Ribble Valley Borough Council  
Council Offices  
Church Walk,  
Clitheroe  
Lancashire  
BB7 2RA

Phone: 0300 123 6780  
Email: [developeras@lancashire.gov.uk](mailto:developeras@lancashire.gov.uk)  
Your ref: 3/2026/0217  
Our ref: 3/2026/0217/HDC/KW  
Date: 30 April 2026

**Location:** Thornley Hall Farm Up Bedlam Road Thornley PR3 2TN  
**Proposal:** Reserved matters application relating to appearance, landscaping, layout and scale following outline planning permission 3/2025/0289.  
**Grid Ref:** 363424 441074

| Drawing No: Air/1164/3803 - 01 | Drawn: MP |

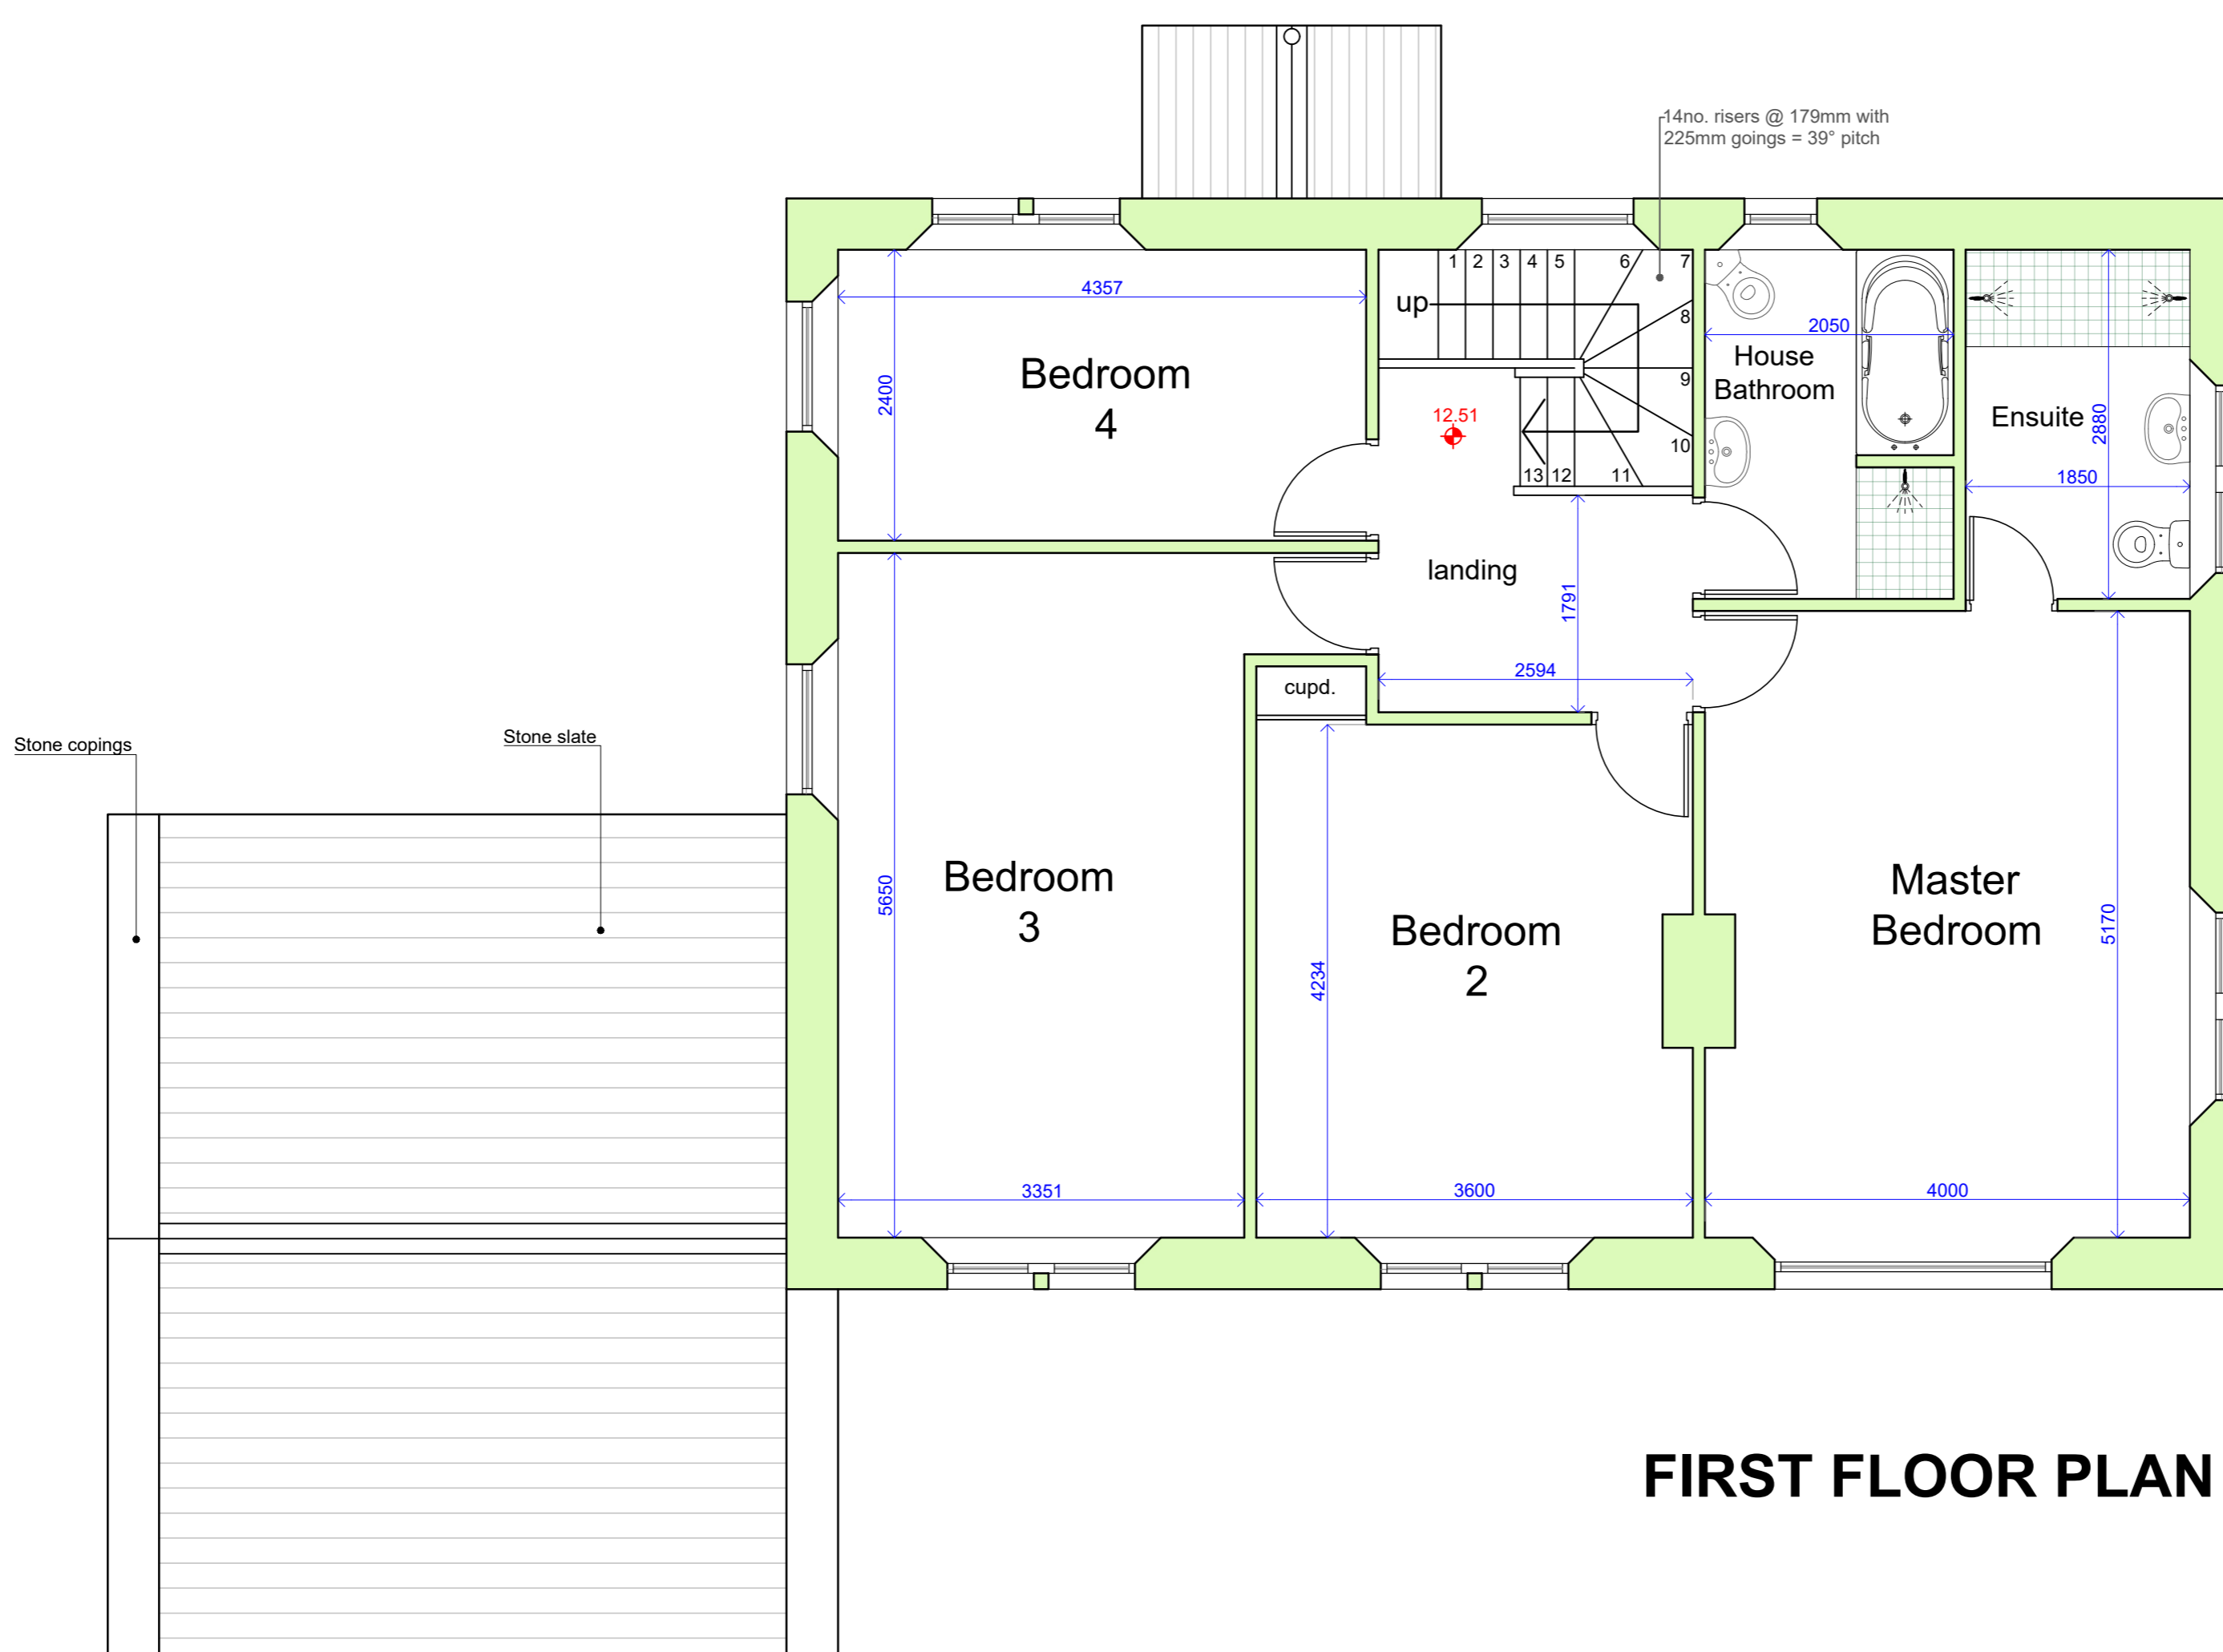
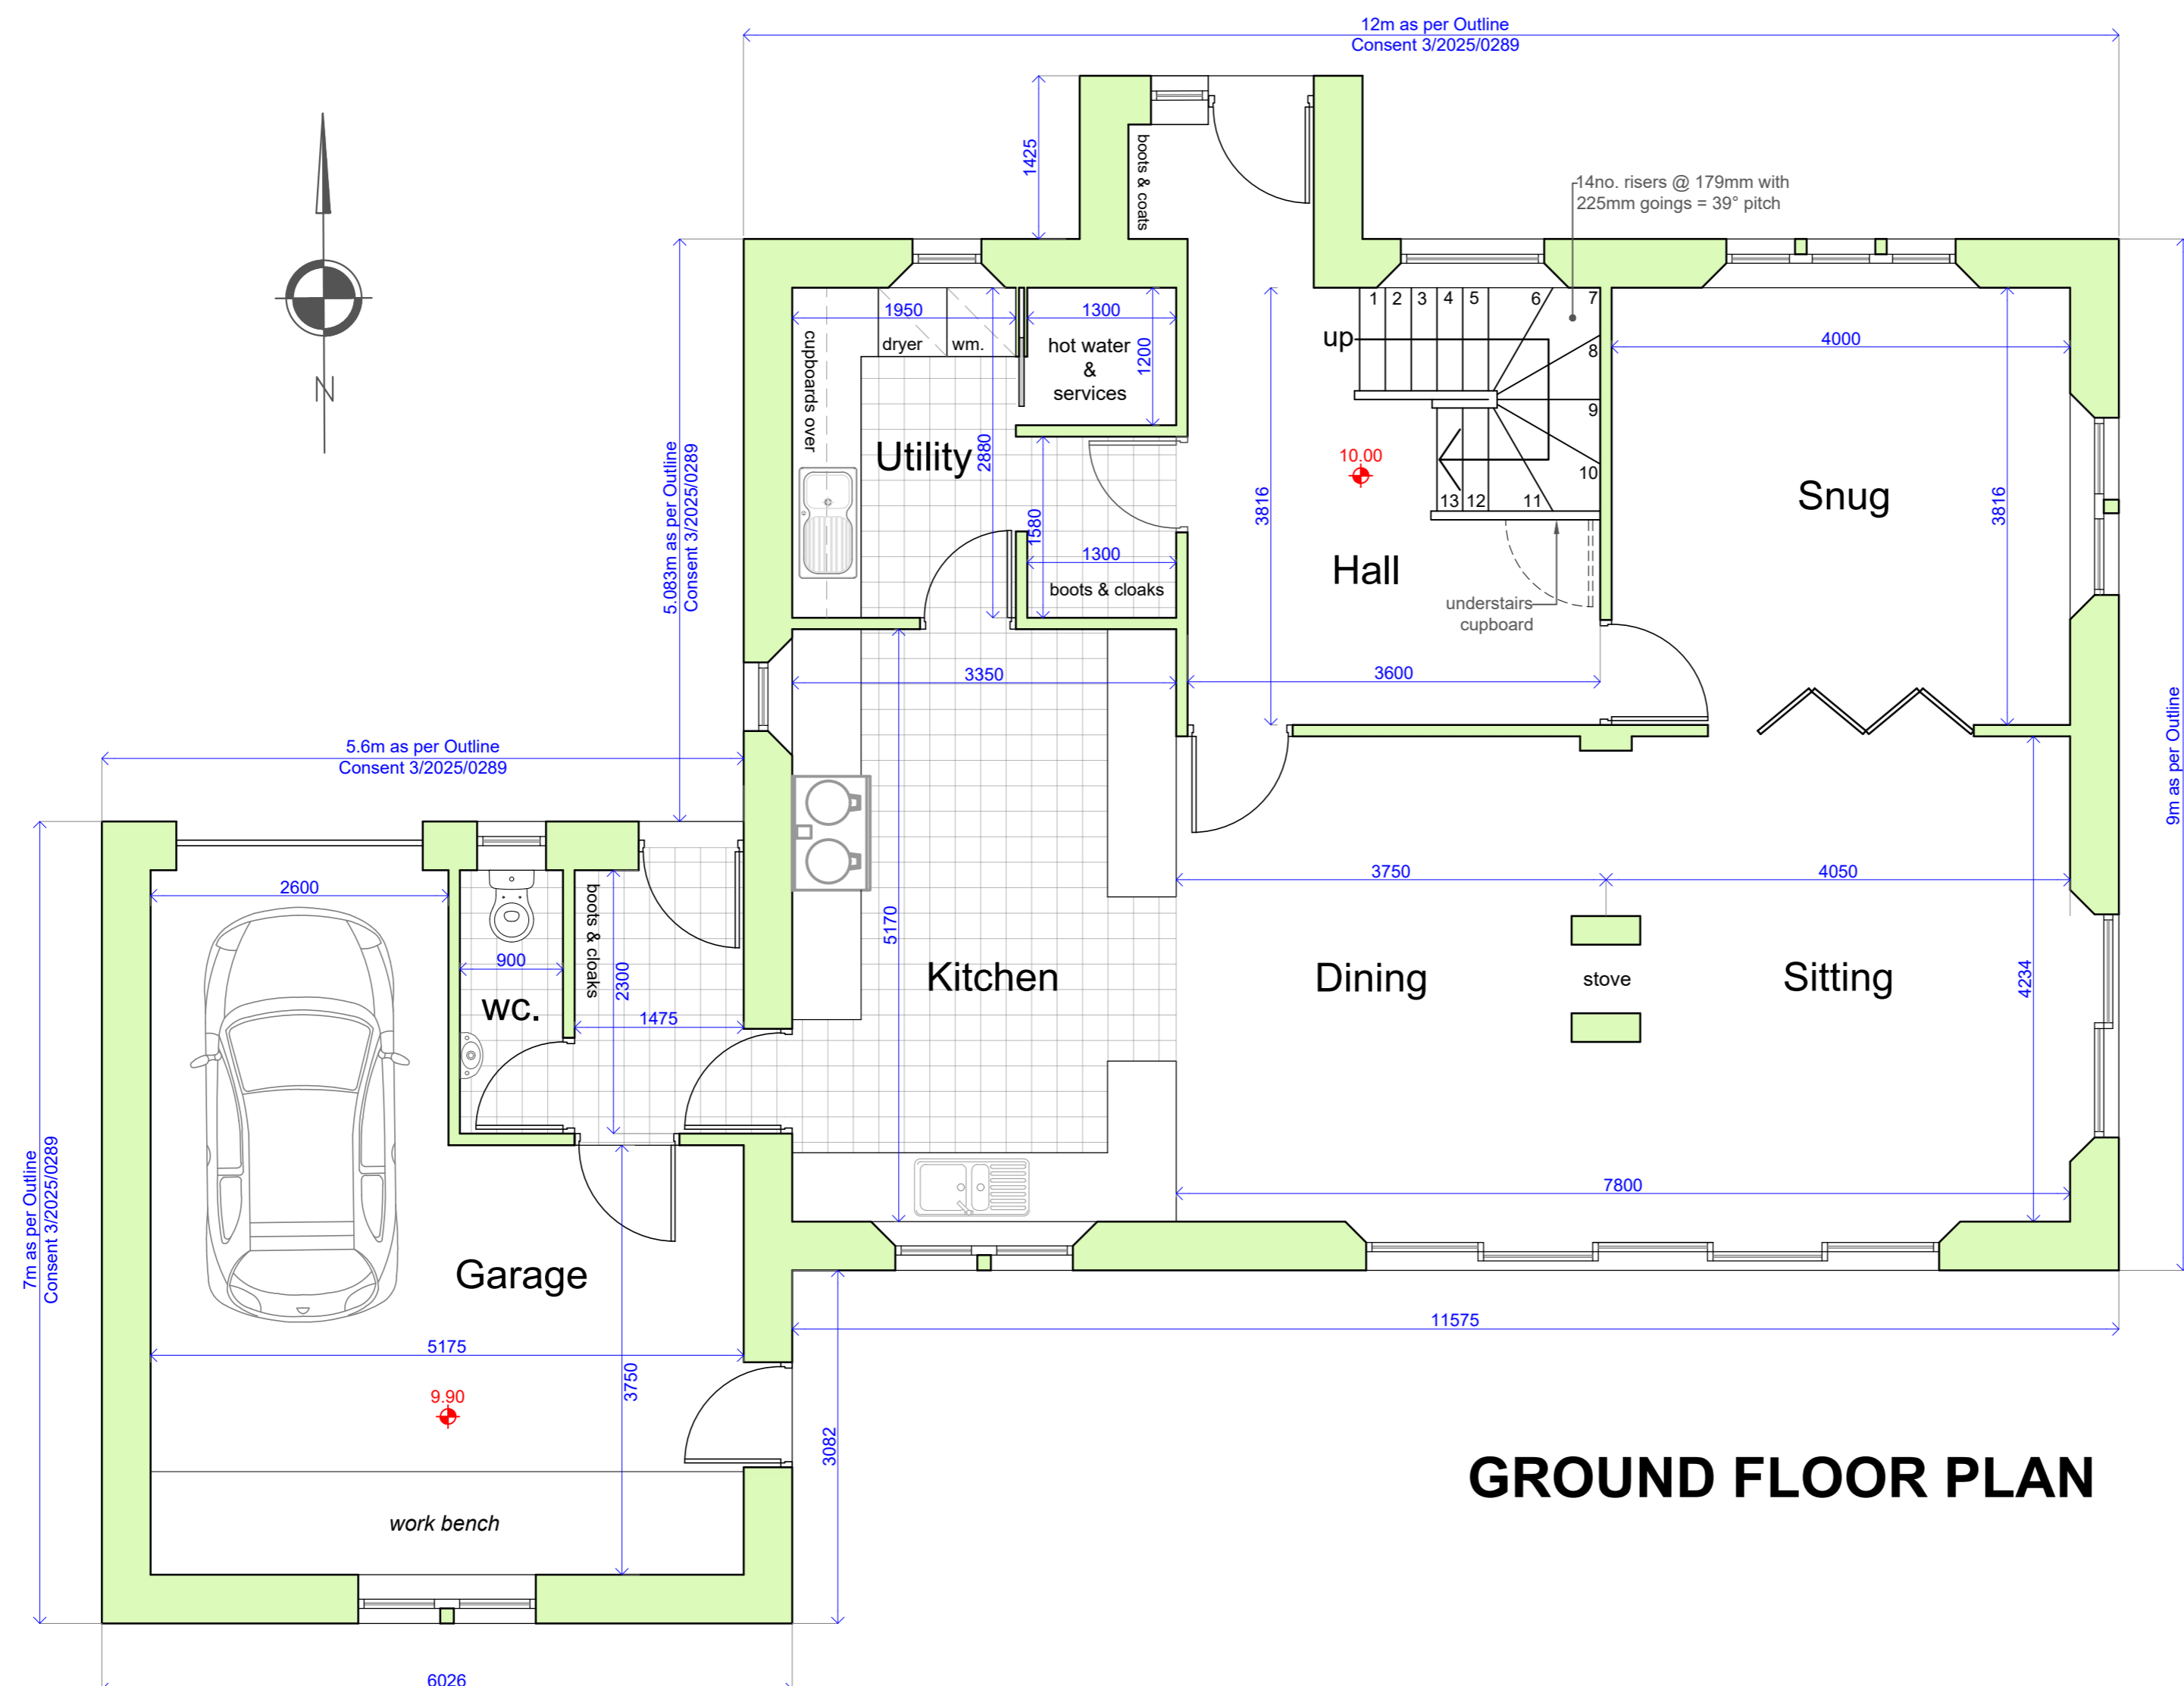
The LHA has reviewed the internal floor plans within drawing Air/1164/3803 - 01, which includes a garage. The proposed integrated garage does not meet the recommended minimum internal dimensions for a single garage size, which is 6m in length and 3m wide. As such, the LHA would not view the garage as providing parking provisions, however the external driveway provides acceptable space to provide 3 off street parking spaces and manoeuvring space.
